EPC STORMWATER REVIEW COMMENTS
IN ORANGE BOXES WITH BLACK TEXT

FINAL DRAINAGE REPORT

MAYBERRY, COLORADO SPRINGS – FILING NO. 2A

SEPTEMBER 2023

FILING 2A PROP.
DRAINAGE MAP

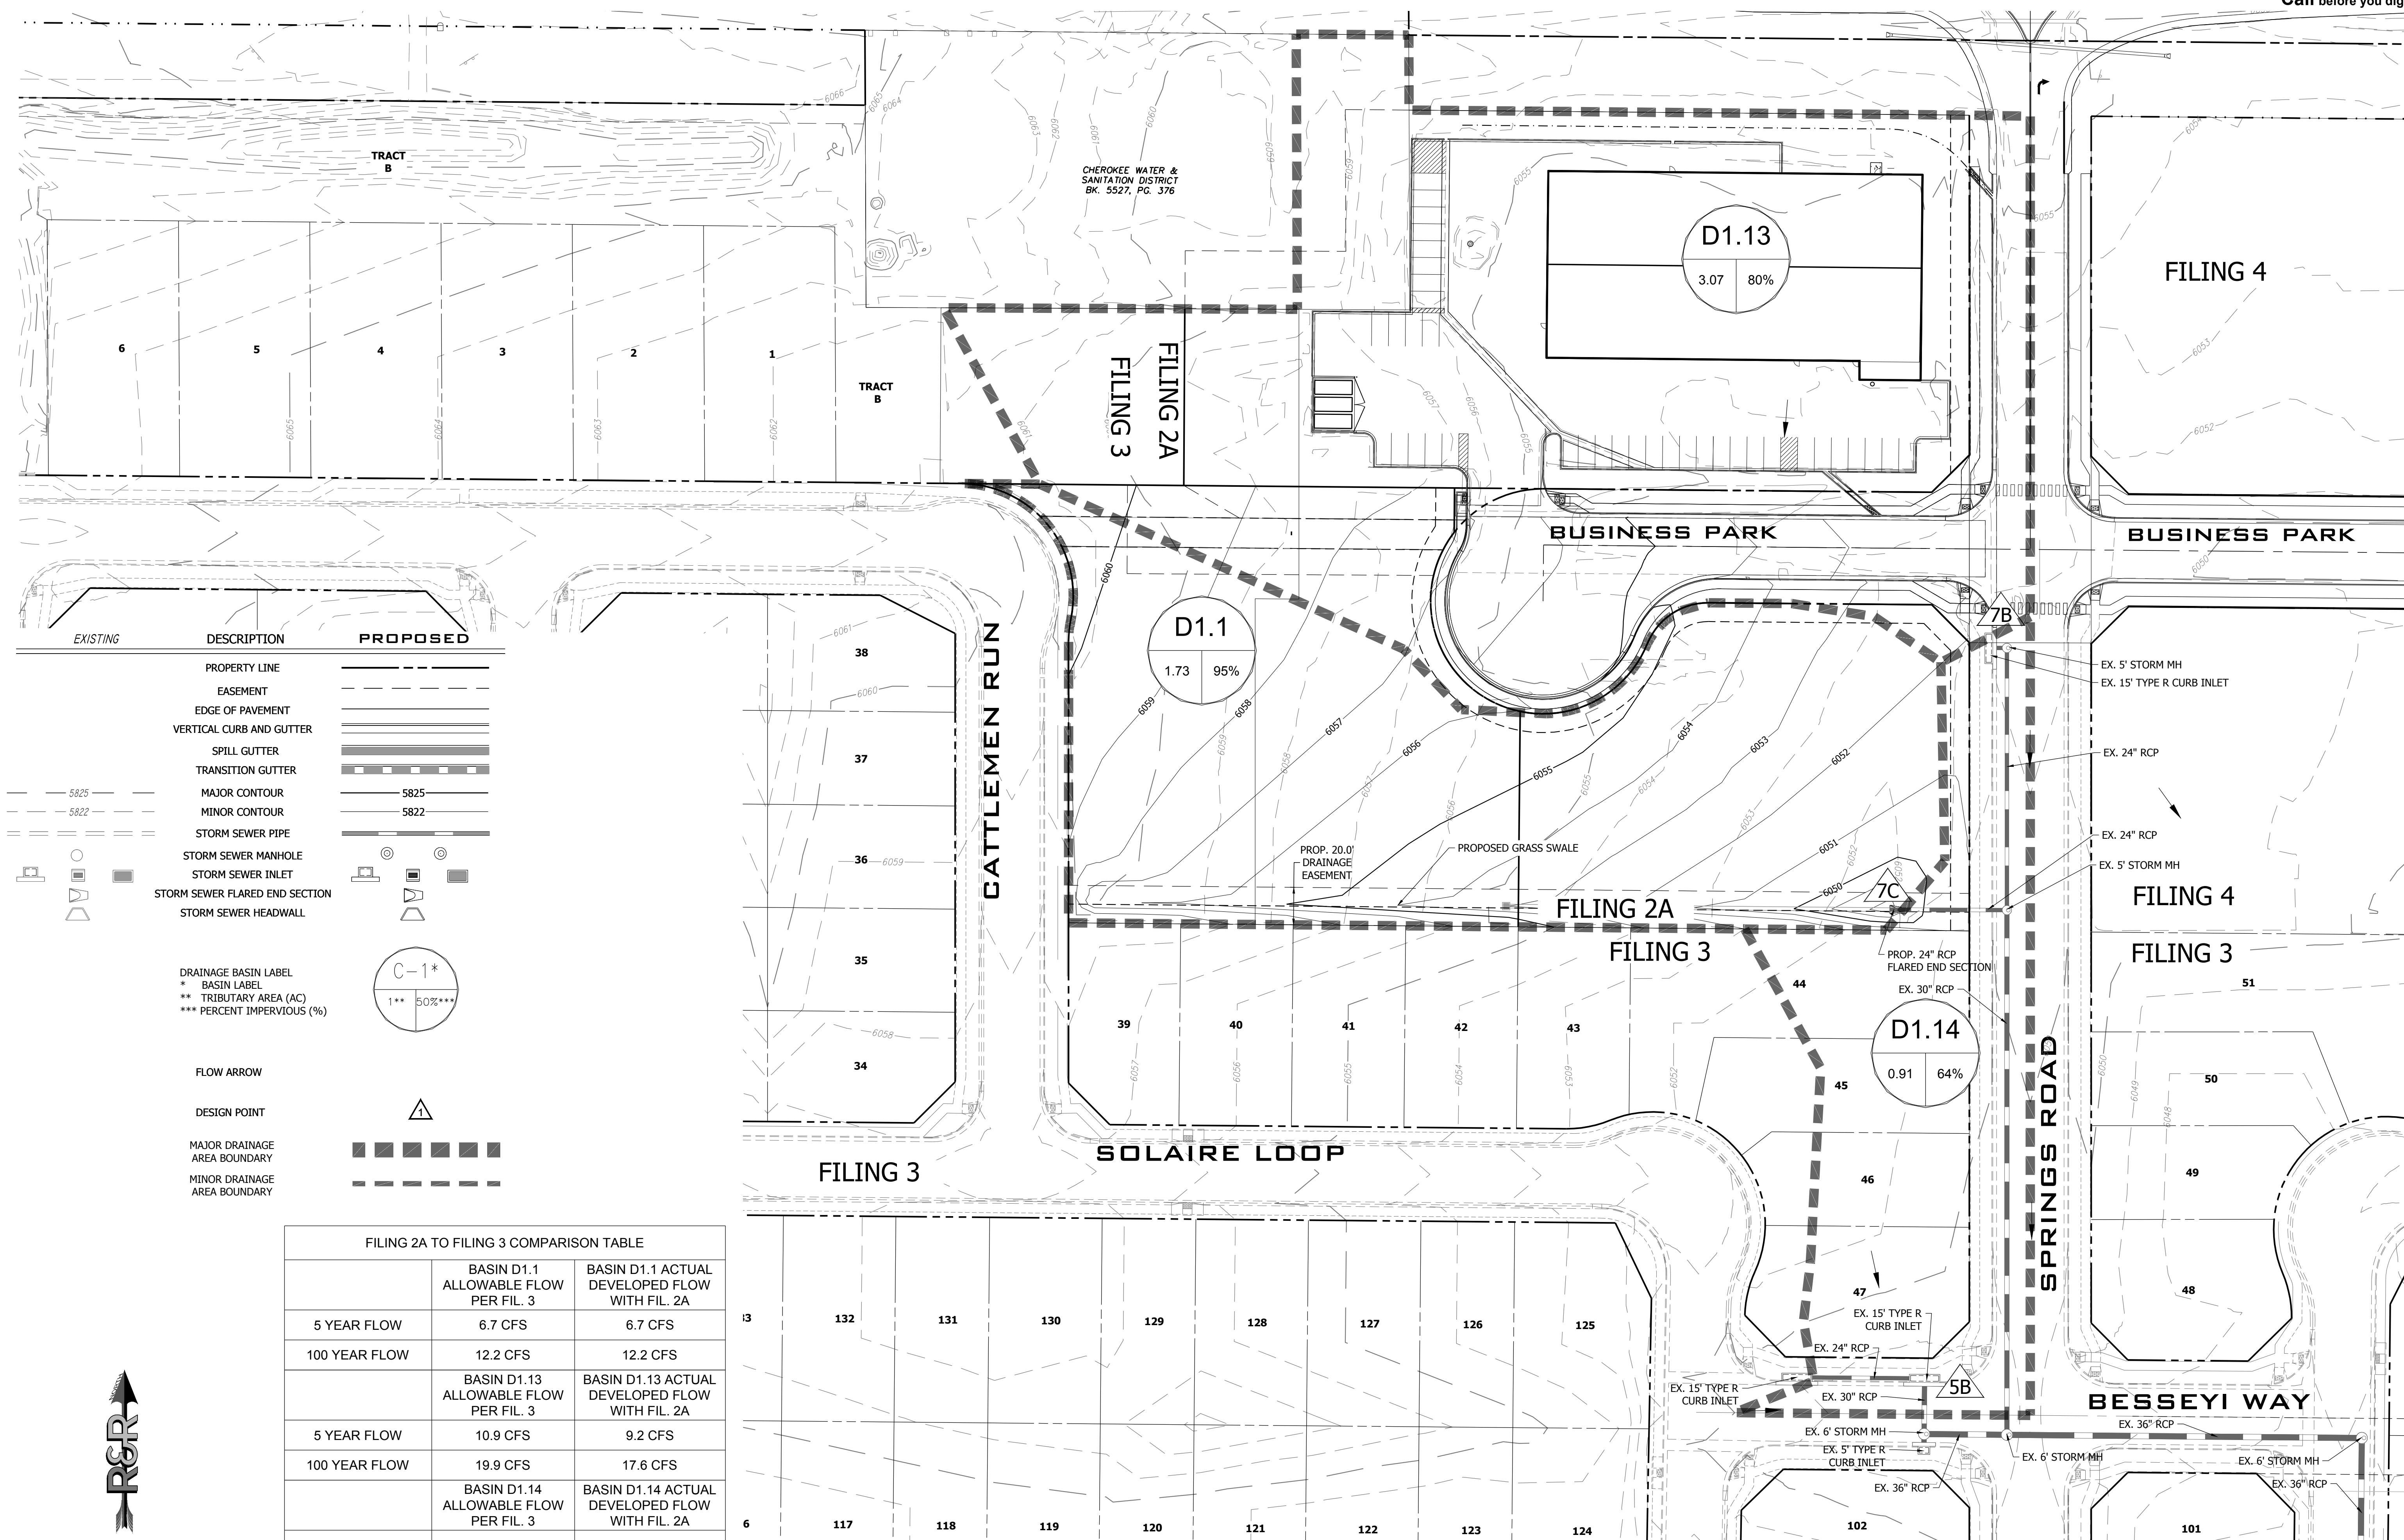
This needs to be verified and updated to match throughout. Above it is stated that the Filing 3 FDR is undergoing review and is not approved.
